**Consultation Response from KC,
Highways Development Management**

2024/93026 land at, Manor Street, Newsome, Huddersfield, HD4 6NW

Discharge of details reserved by conditions 3 (materials), 5-9 (site contamination), 11 (external lighting), 12 (cycle parking), 13 (bin store), 14 (ecological design strategy), 15 (landscaping) and 16 (drainage) of previous permission 2022/90655 for erection of 10 student residential units with associated landscaping

Date Responded: 29/11/2024

DRAWING TITLE
SITE PLAN - PROPOSED

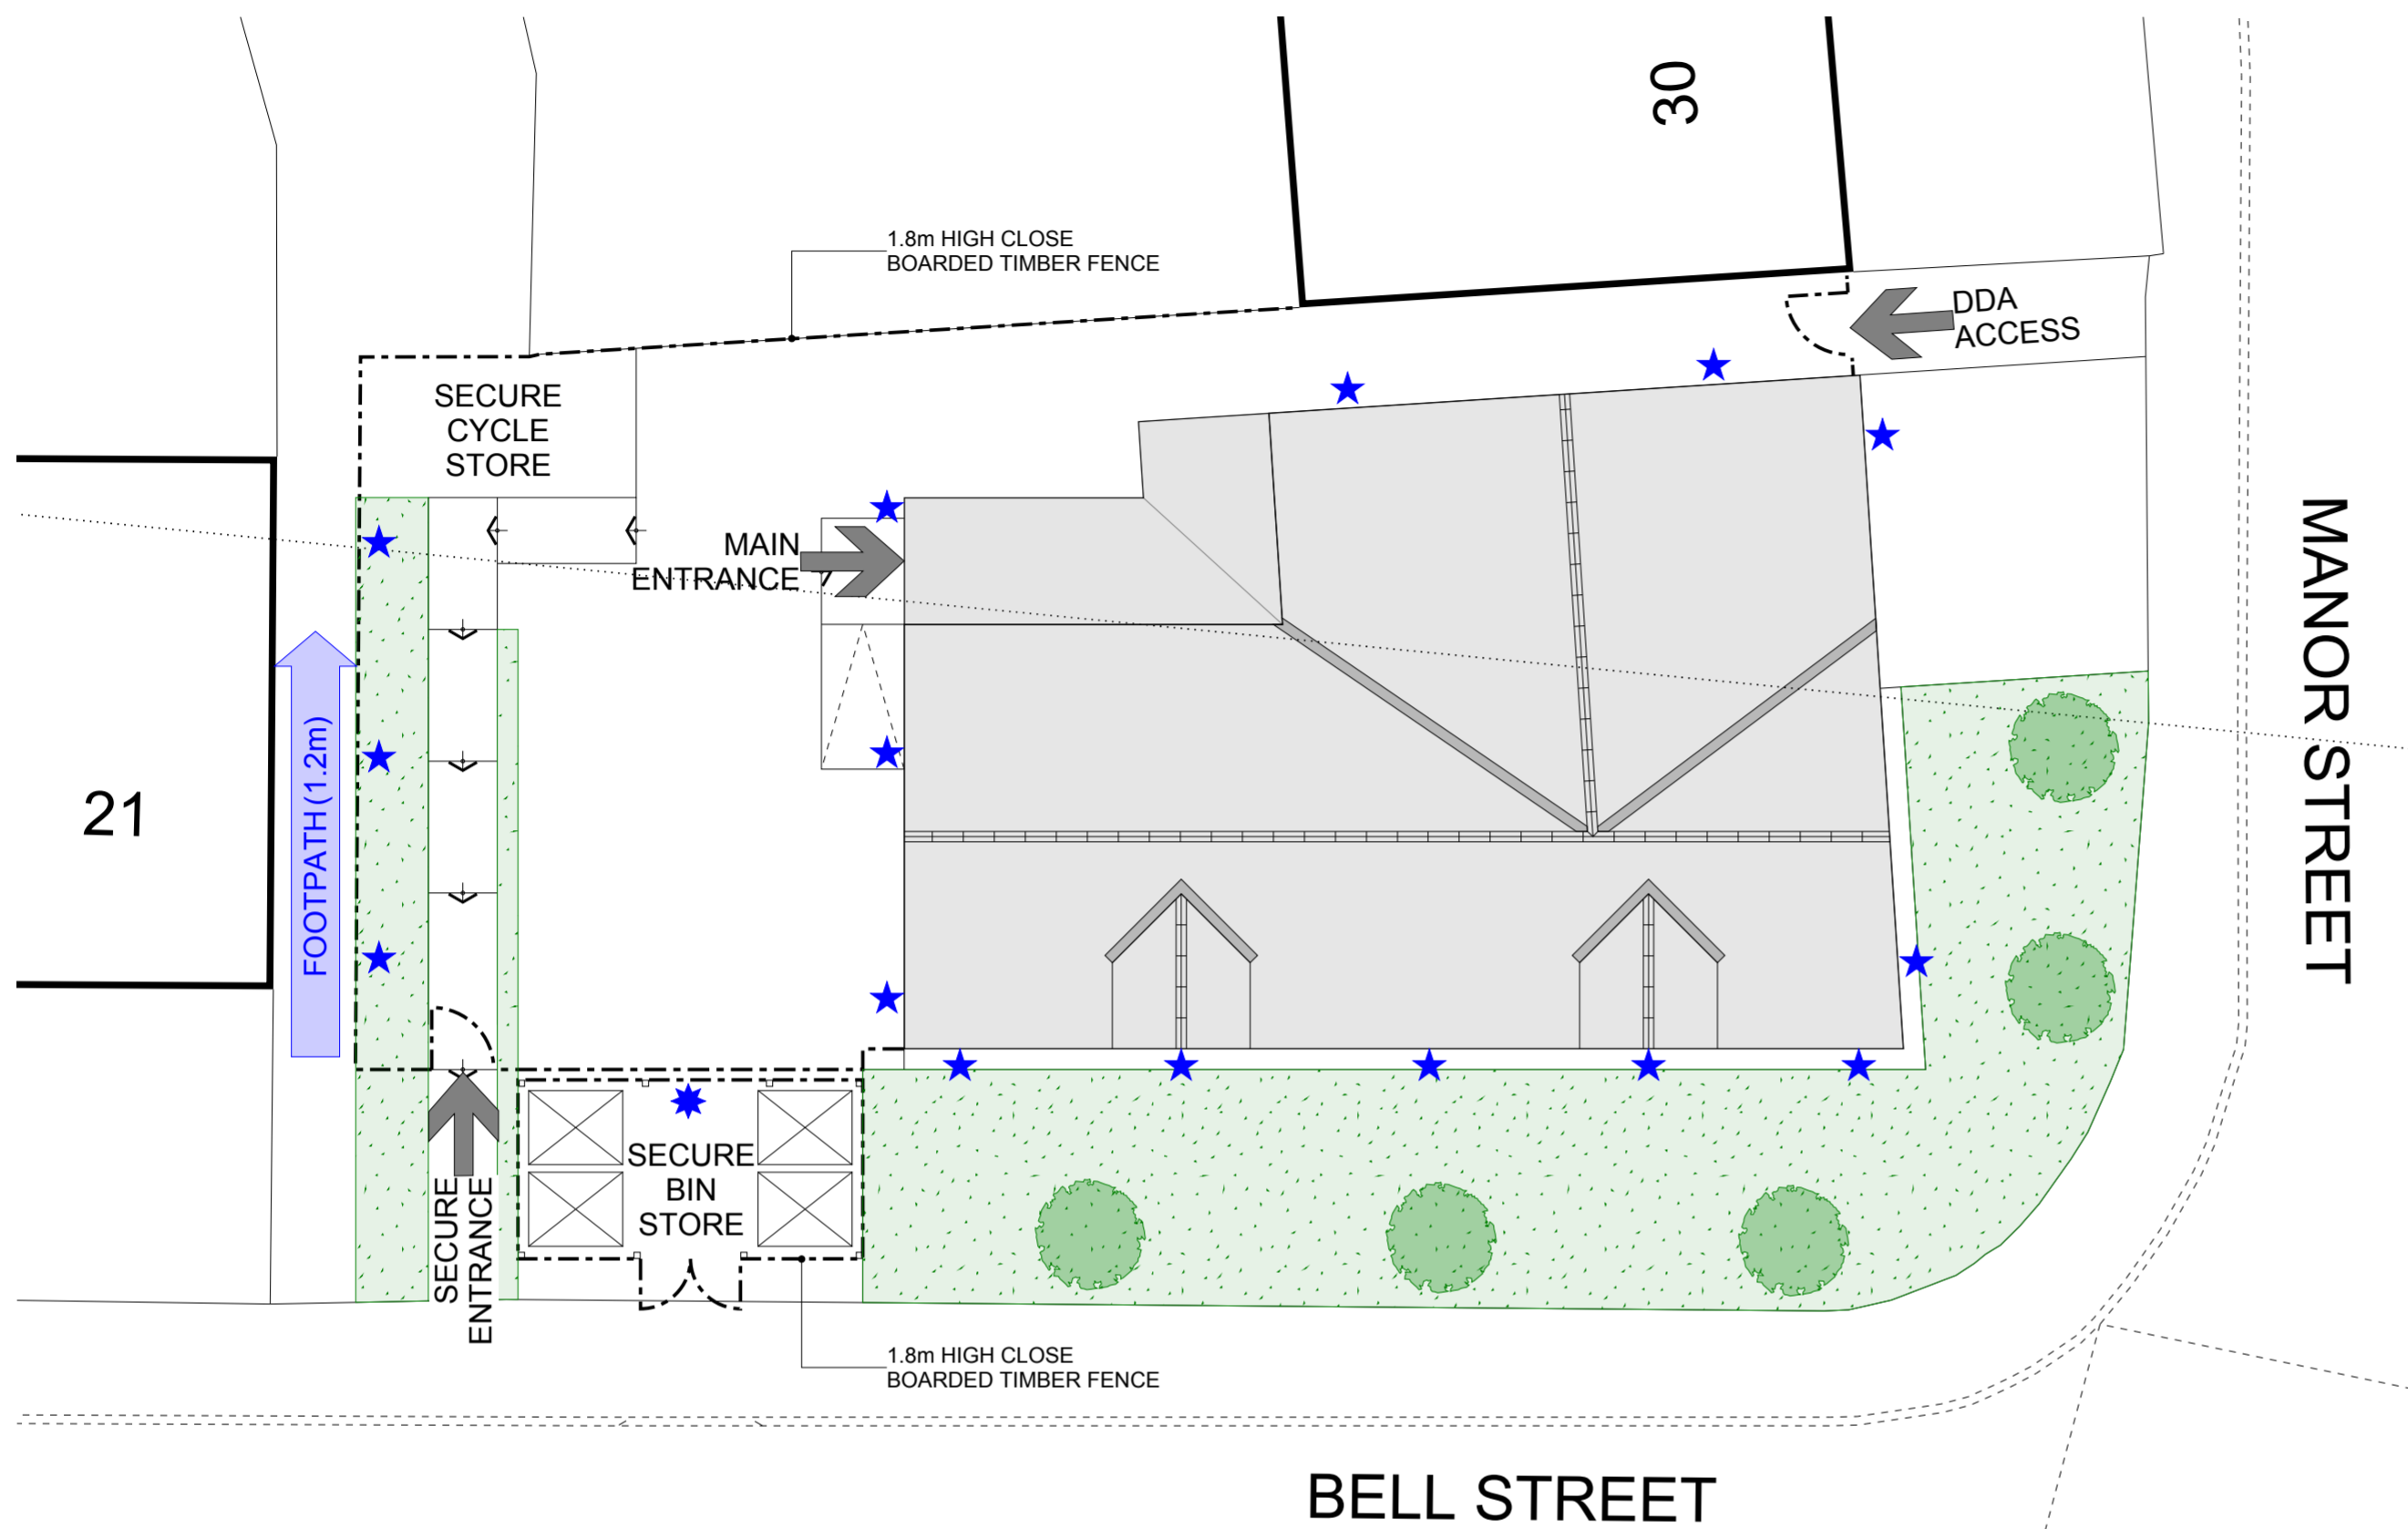
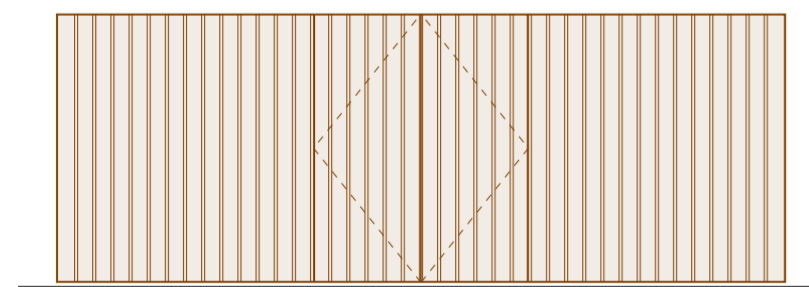
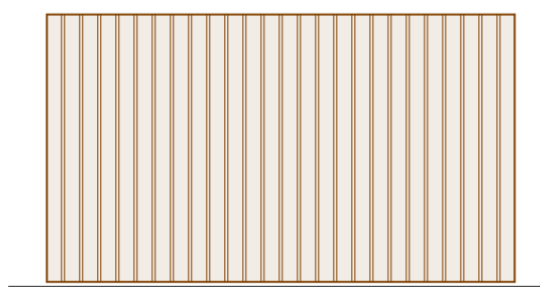
The information provided within this DoC application includes drawing No 4165-21 Site Plan, Proposed. This shows the location of a “secure cycle store” and includes a photo of some low cycle wheel loops. This is insufficient to provide safe and secure storage of cycles at the site. We would wish to see details of a covered and lockable structure that contains as a minimum some Sheffield style stands that allow the body of the cycle to be securely anchored/locked (rather than the wheel hoops as shown), but ideally some form of cycle locker or wall mounted stand. If the cycle storage doesn’t appear safe and secure it will deter cyclists from storing their cycles there for fear of theft, damage or wear due to the weather. This would not support the council’s requirements to support sustainable and active travel.

At this time, we cannot support the discharge of condition 12 until details of a suitably safe and secure covered store with anchoring points is provided.

The information provided with this DoC application shows the bin storage/collection point as being adjacent to the rear of the adopted highway and for Highways this is acceptable for the discharge of condition 13 on highways grounds, however for details of the suitability and size of the store we would defer to the consultation response from our colleagues in the Kirklees Waste Strategy team.
